CITY OF ALBUQUERQUE

September 28, 2018

**RE: Signal Village Subdivision
Signal and Ventura NE
Grading Plan Stamp Date: 9/10/18
Drainage Report Stamp Date: 9/10/18
Hydrology File: C20D078**

kearn@tpco.com

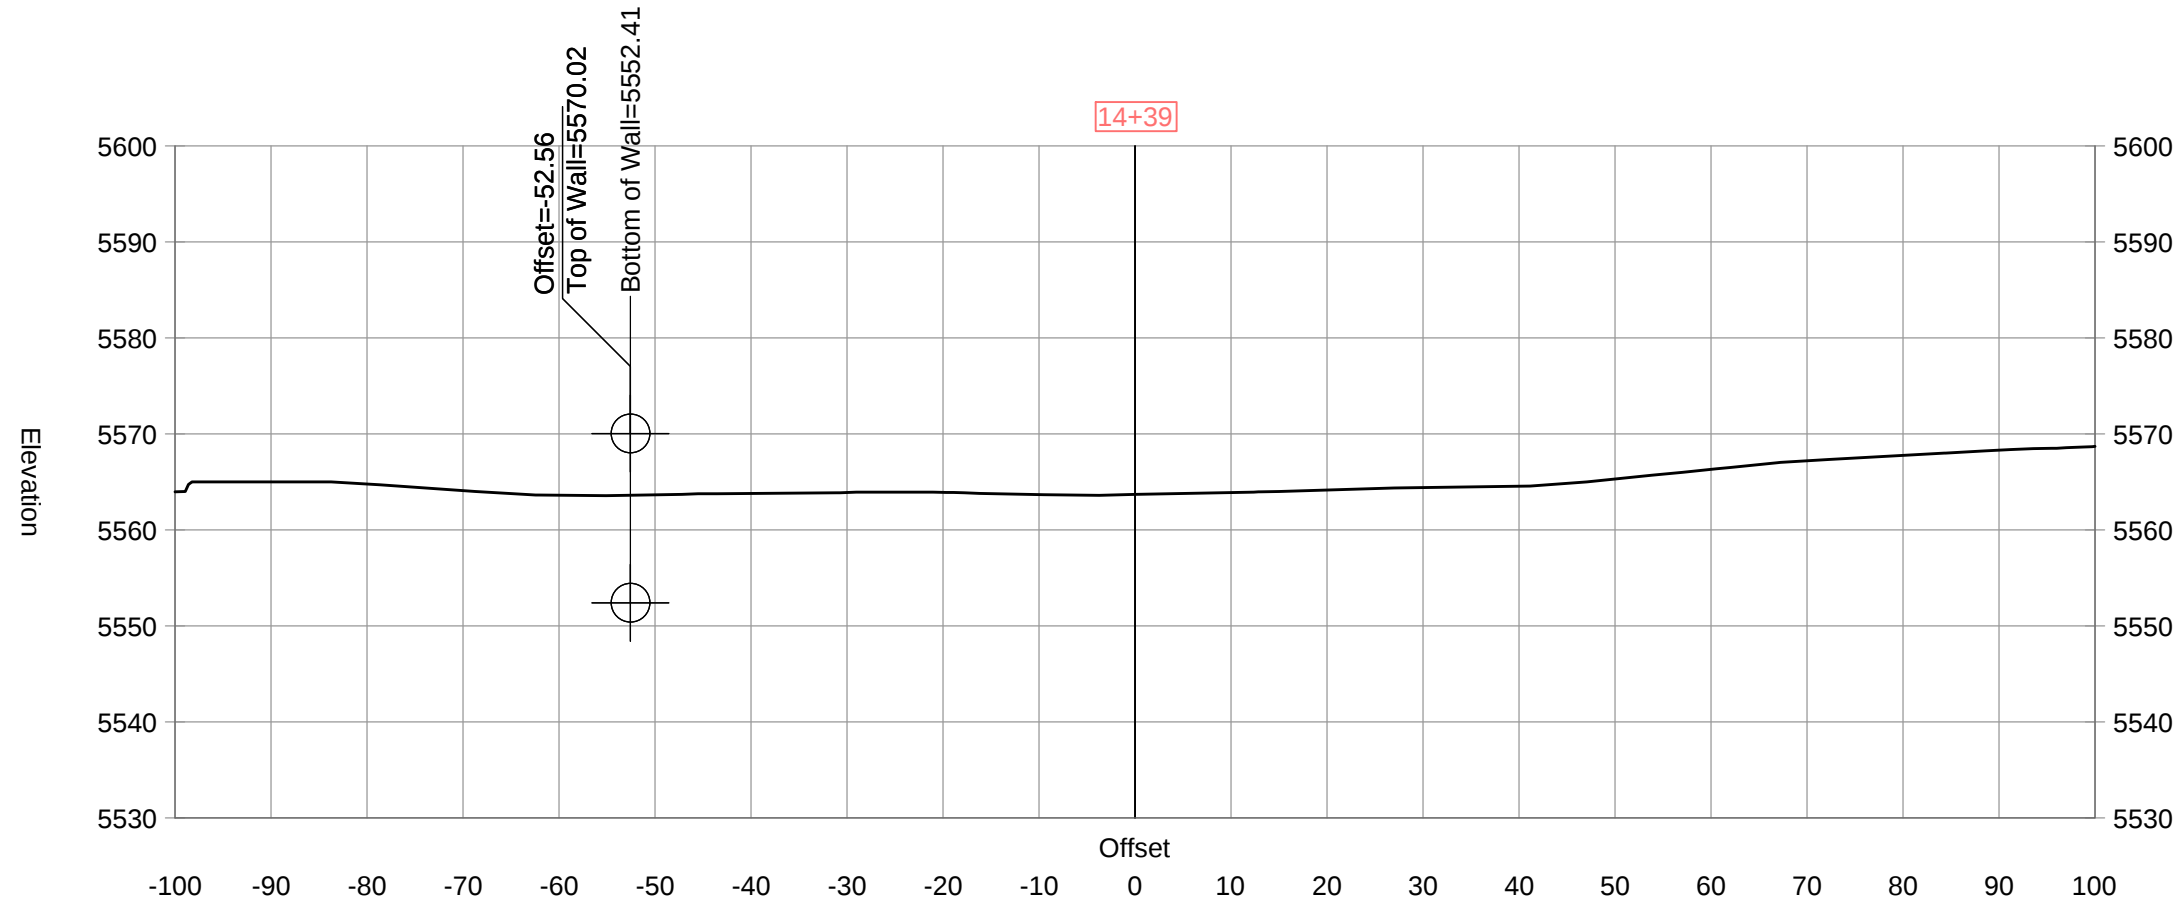
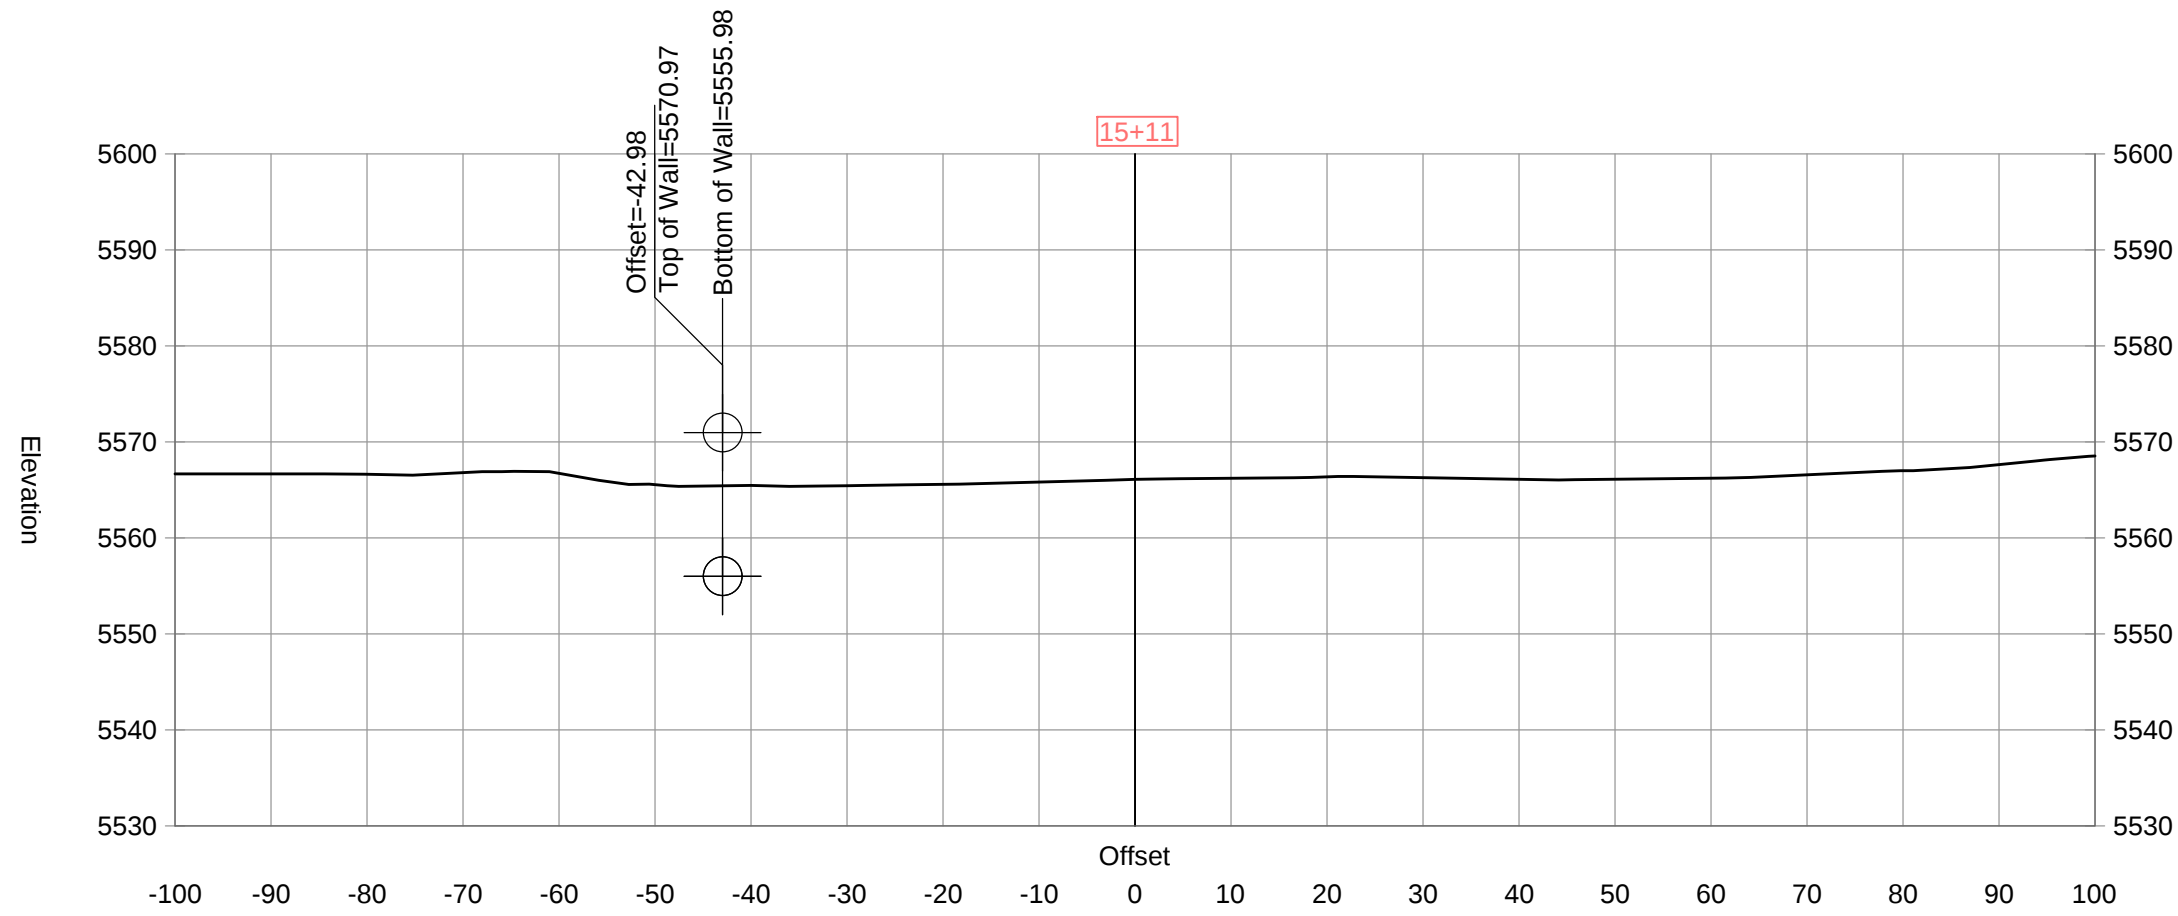
1. Show all infrastructure improvements on the grading plan, especially curb and gutter and sidewalk on Ventura. The return is not in the correct location at Signal/Ventura intersection. Ventura improvements must include curb and gutter and sidewalk and ½ section collector paving section for the full length of frontage. These improvements provide adequate protection from scour so a scour wall is not required on the east side of the project. Dimension face-to-face of curb, and sidewalks on both sides of the centerline. Show connections and transitions to the existing curb and pavement on Signal.

2. Show and label the existing and proposed contours, including all proposed grading both onsite and offsite and label limits of grading. Extend limits of existing topo to include the ROW on Ventura, south of the Ventura/Signal intersection; include curb returns.

3. Provide additional details for the first flush pond; show the water surface elevations for both the first flush volume and the 100-yr volume. Include supporting calculation for the overflow channel as well (Both the overflow channel and the pond will need to be dedicated as private drainage easements on the Plat). Correct notes on the grading and drainage plan under *Developed Drainage Condition* to describe the central first flush pond and its overflow north to the arroyo, not south to Signal.

4. Typical sections are required at all retaining walls (not just the scour wall) at the point of maximum retainage showing existing ground, proposed grades, lot lines, and dimensions.

11. The scour wall is shown as being constructed from CMU block which is constructed in level runs, but the profile shows the scour wall as sloping along its length. The location of the steps should be called out on the plan for the footer and top of wall.

12. The footing of the scour wall looks too small. It has to support the wall after the soil is removed from the low side to the scour depth. Provide structural calculations including loading assumptions.
